April 30, 2025

Re: Matthews Landing Amenity Center and Pool

This department has reviewed the plans you submitted for the Matthews Ridge swimming pool to be constructed in Lillington, NC. This plan review was conducted in accordance with the current North Carolina Rules Governing Public Swimming Pools (15A NCAC 18A .2500).

1 Enlarged Restrooms

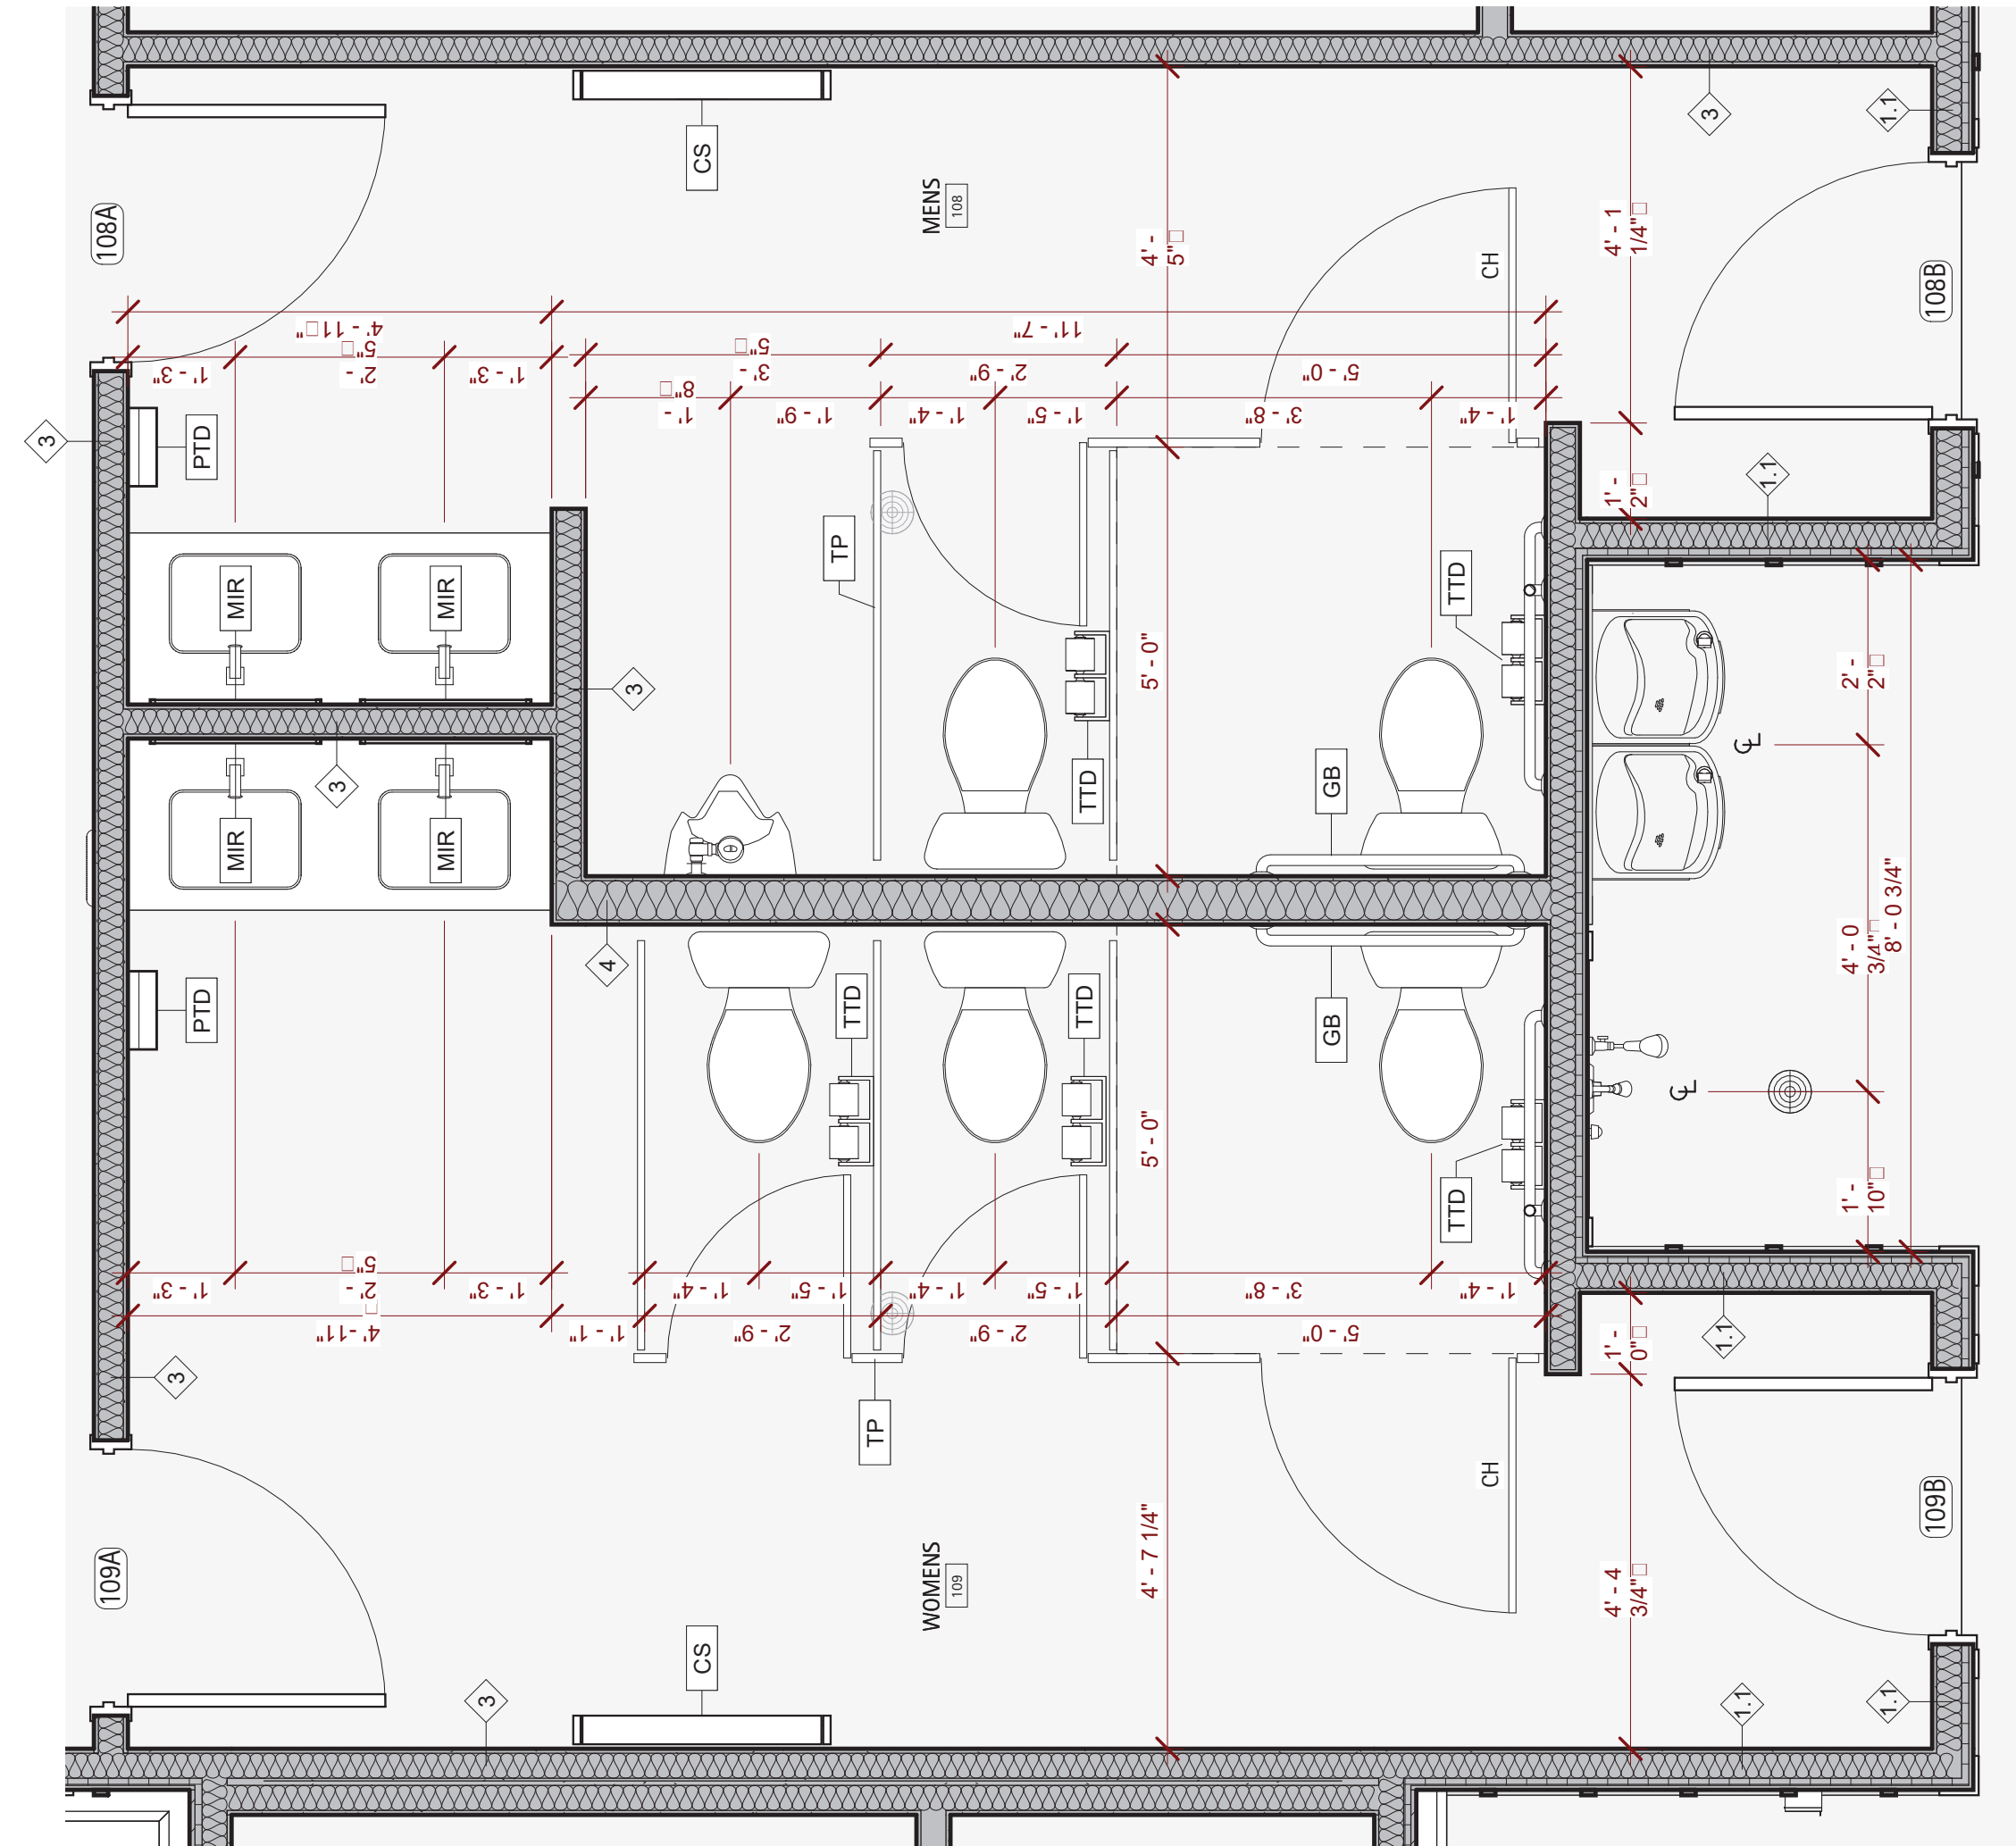
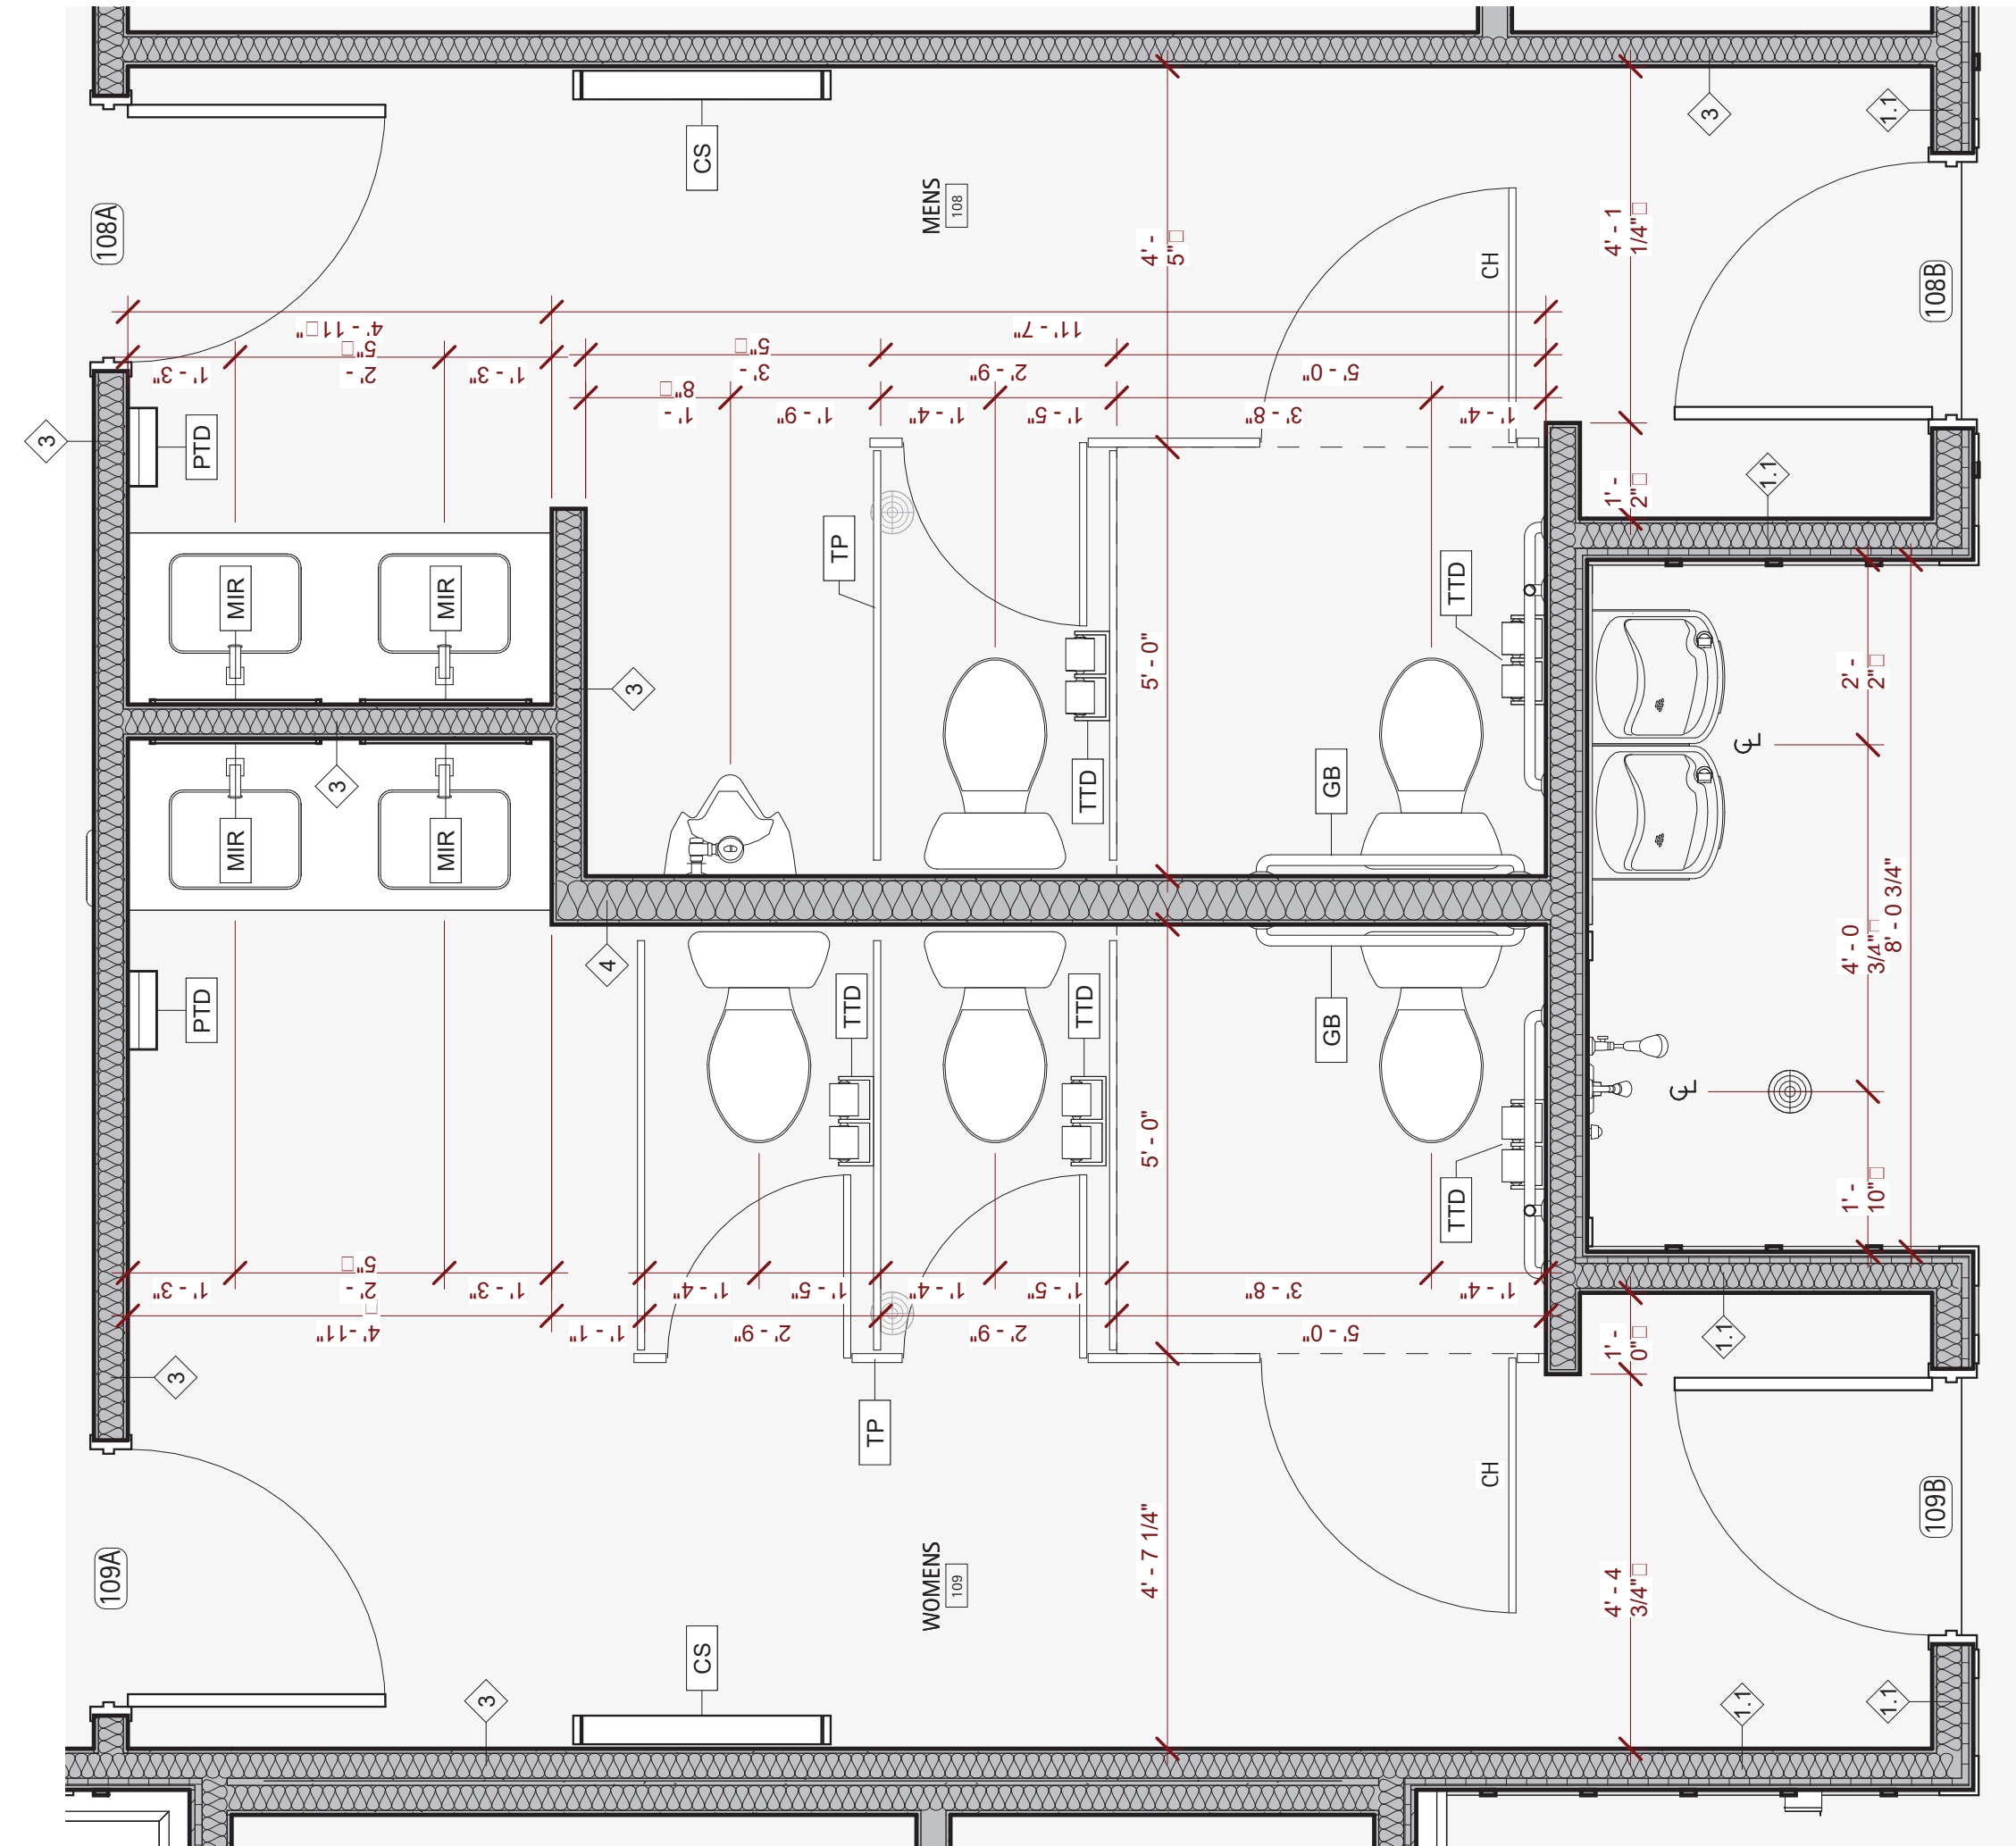
-Soap dispensers are required and shall be provided at each lavatory per 15A NCAC 18A .2526 (j). No soap dispersers are shown on page A4.0 Enlarged Plans and Details.

-The fixtures required for a bather load of 212 (106 male and 106 female) as figured by surface area of 3182 sqft divided by 15 sqft per person for areas <5ft or less in depth are 2 toilets, 2 lavatories and 2 urinals for males and 3 toilets and 3 lavatories for females. The current pool restroom plans show 1 less urinal in the male restroom and 1 less lavatory in the female restroom than required. There is a family restroom within the clubhouse great room that could meet the additional requirements provided this restroom is continually available to pool visitors. If the great room is to be secured and bather access denied at any time, the required fixtures shall be provided in the accessible restrooms.
